# KITTITAS COUNTY FIRE MARSHAL'S OFFICE

August 2, 2016

Re: Bradshaw (BL-16-00011)

Proposed

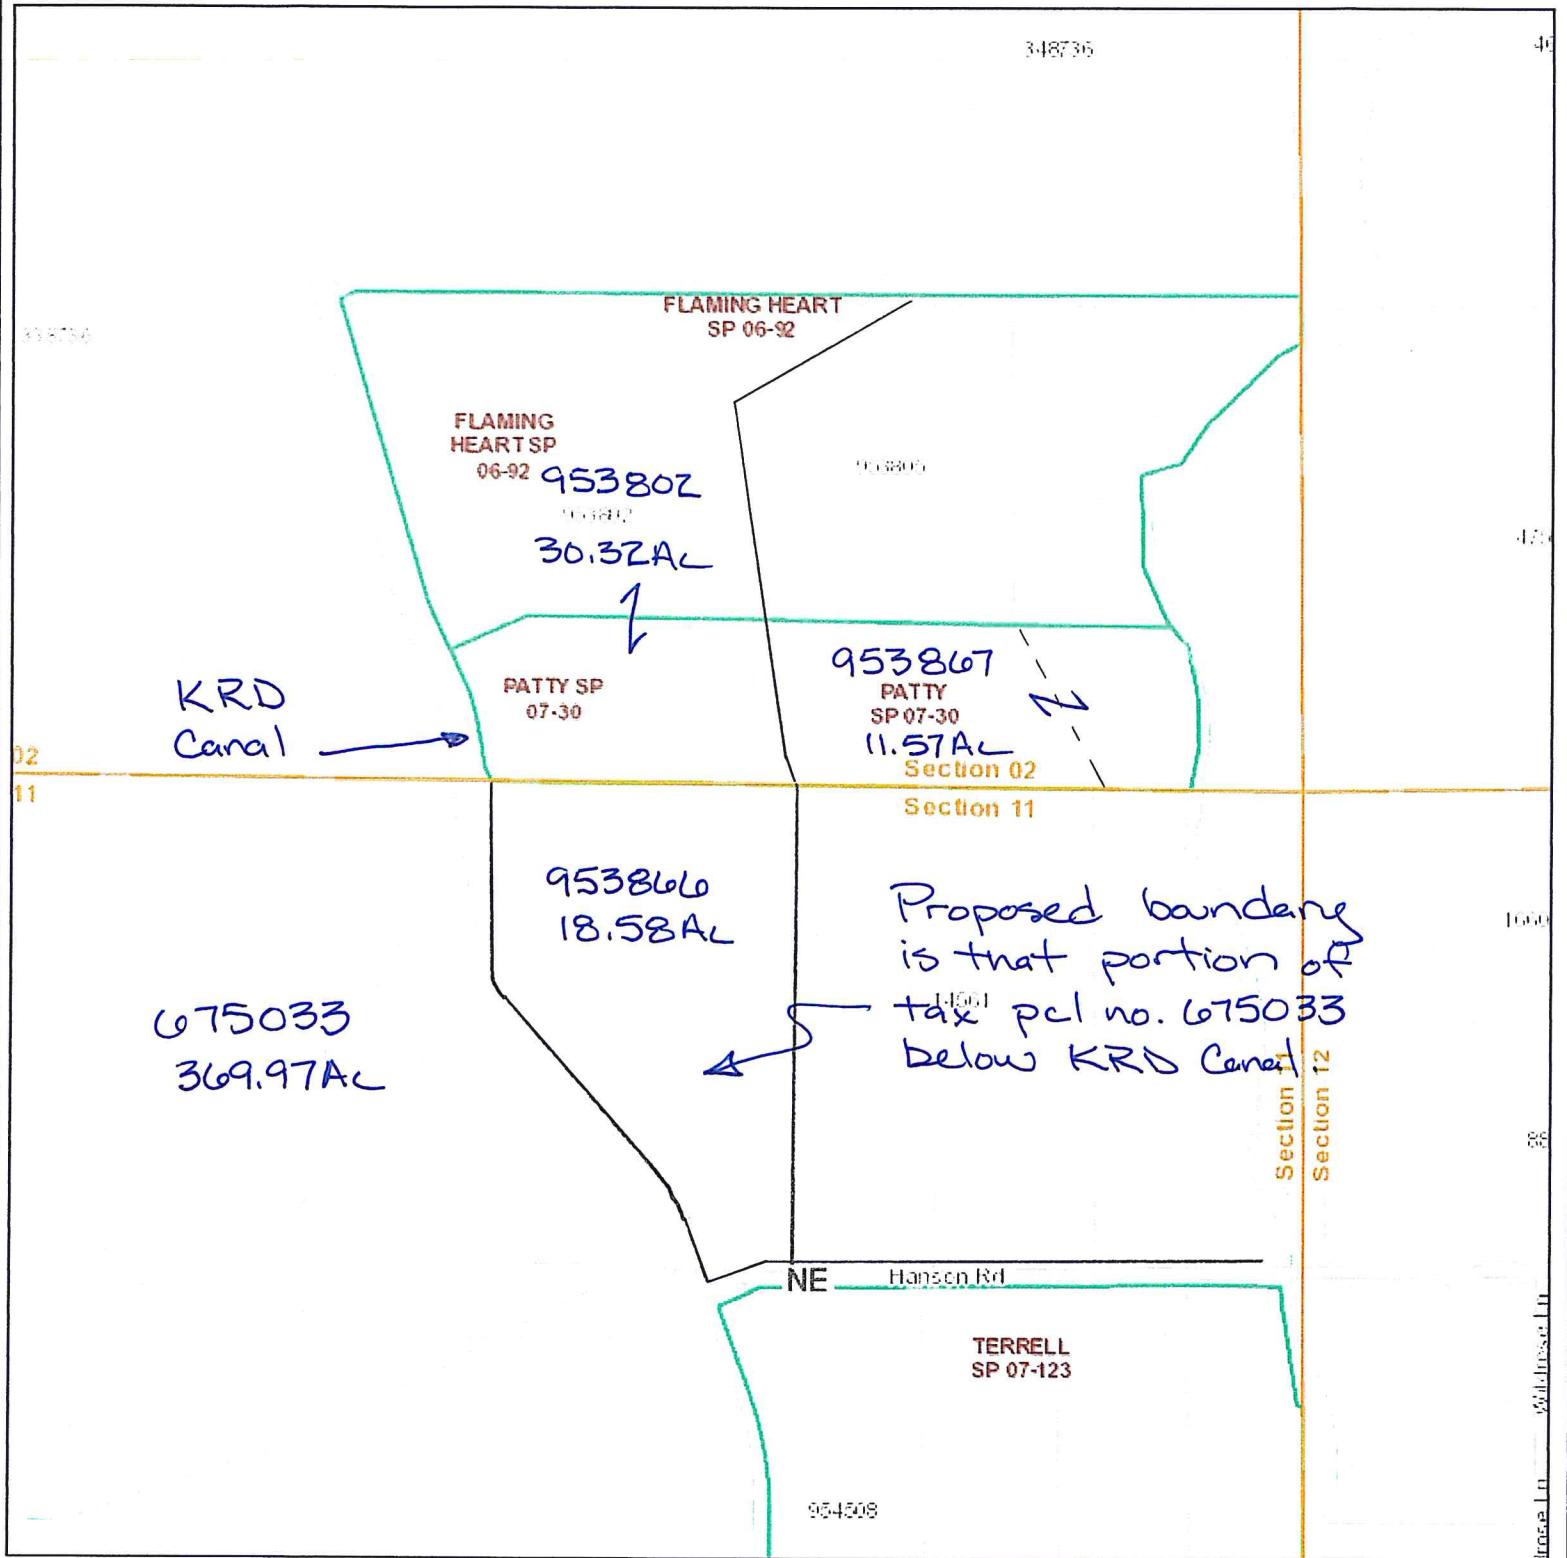
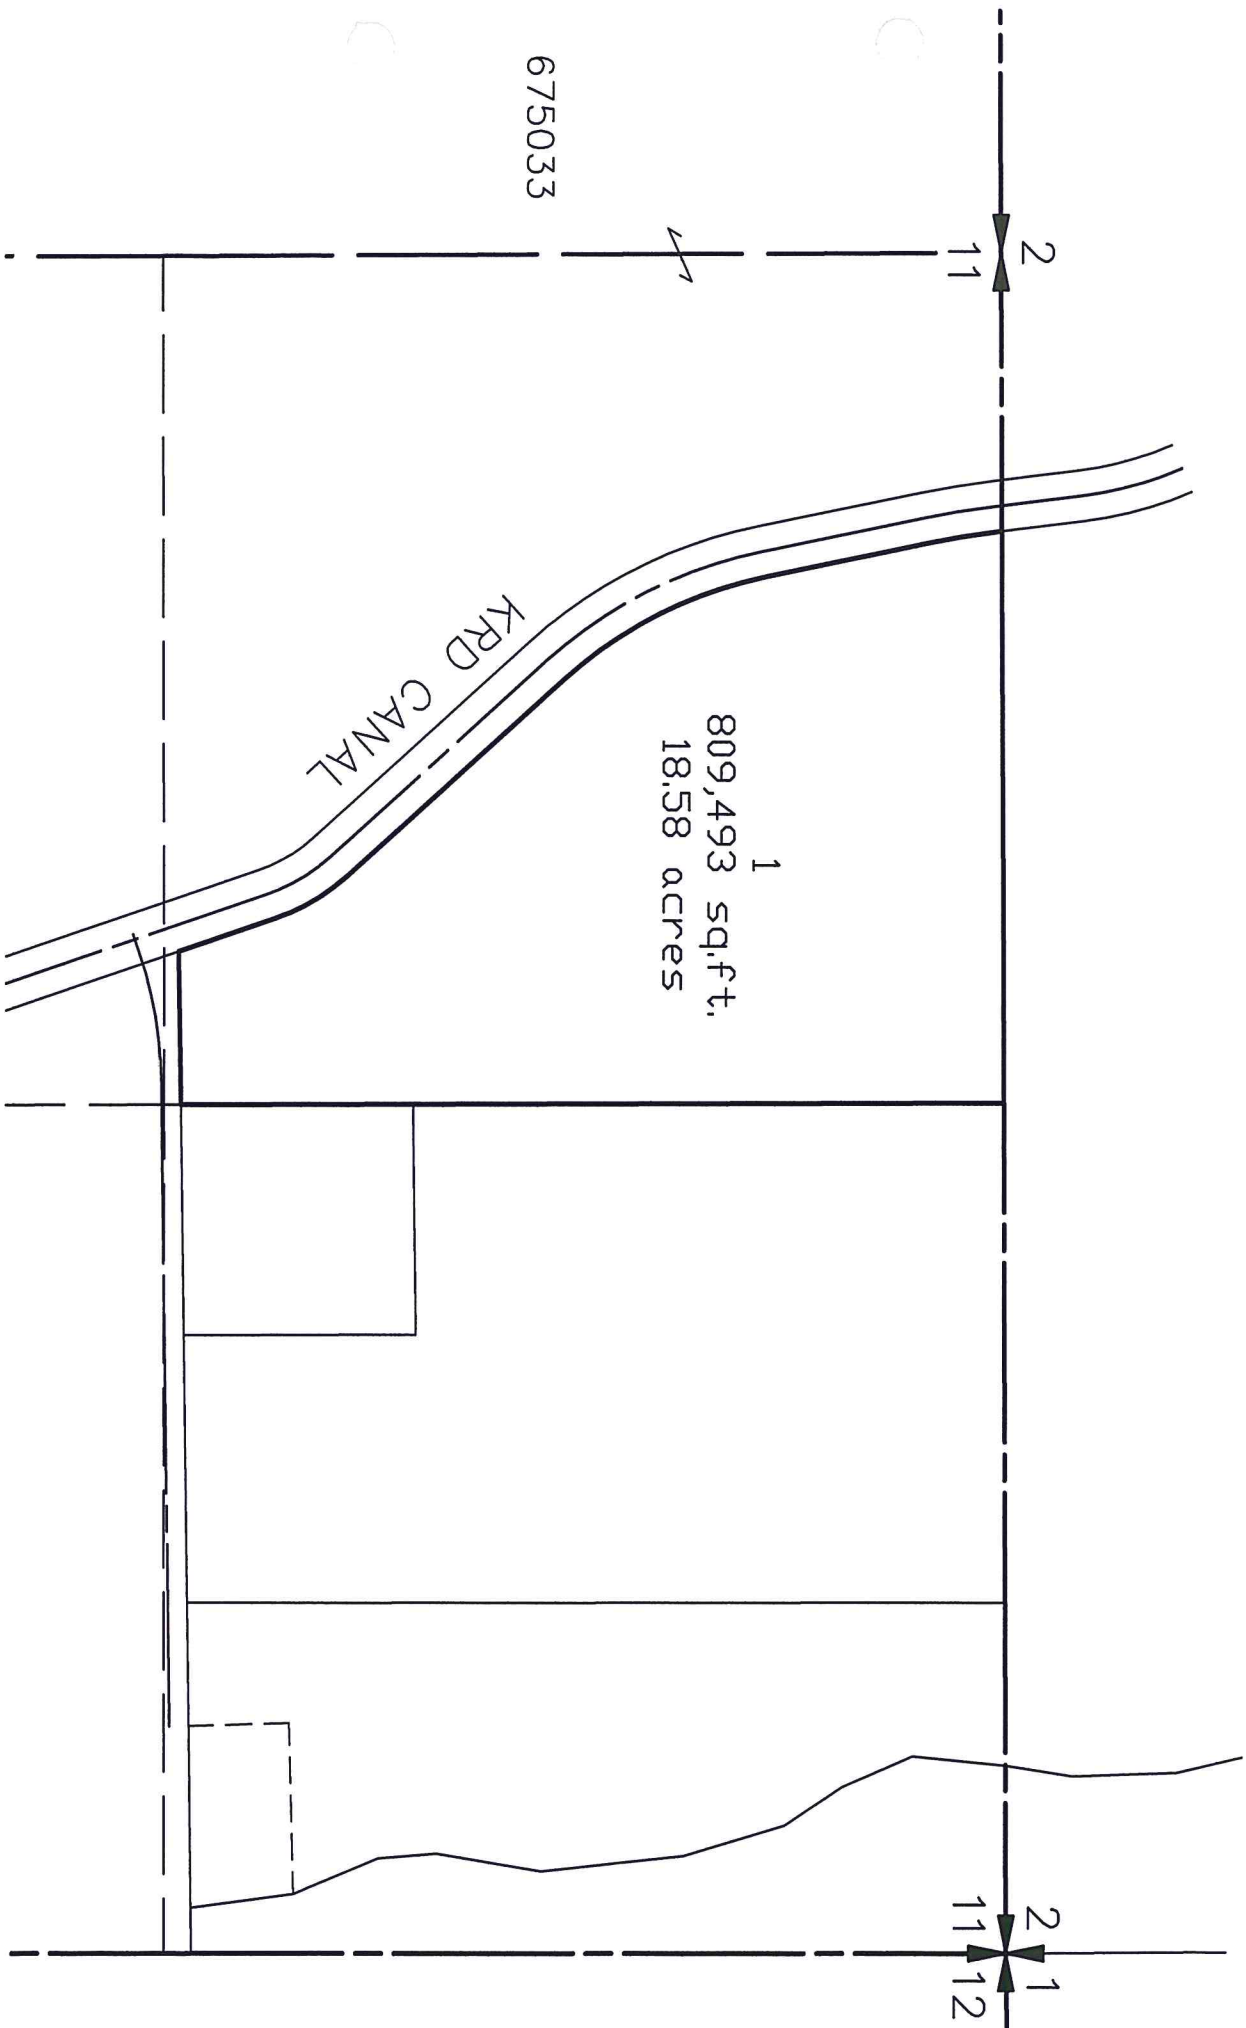
- Ensure that boundary line adjustments do not infringe upon existing structures, to include propane tanks, etc.
- Ensure adequate access for fire apparatus. Any driveways or access points created based off the new lot configurations shall comply with Kittitas County Code 20.02.030.
- All future development must comply with the International Fire Code.
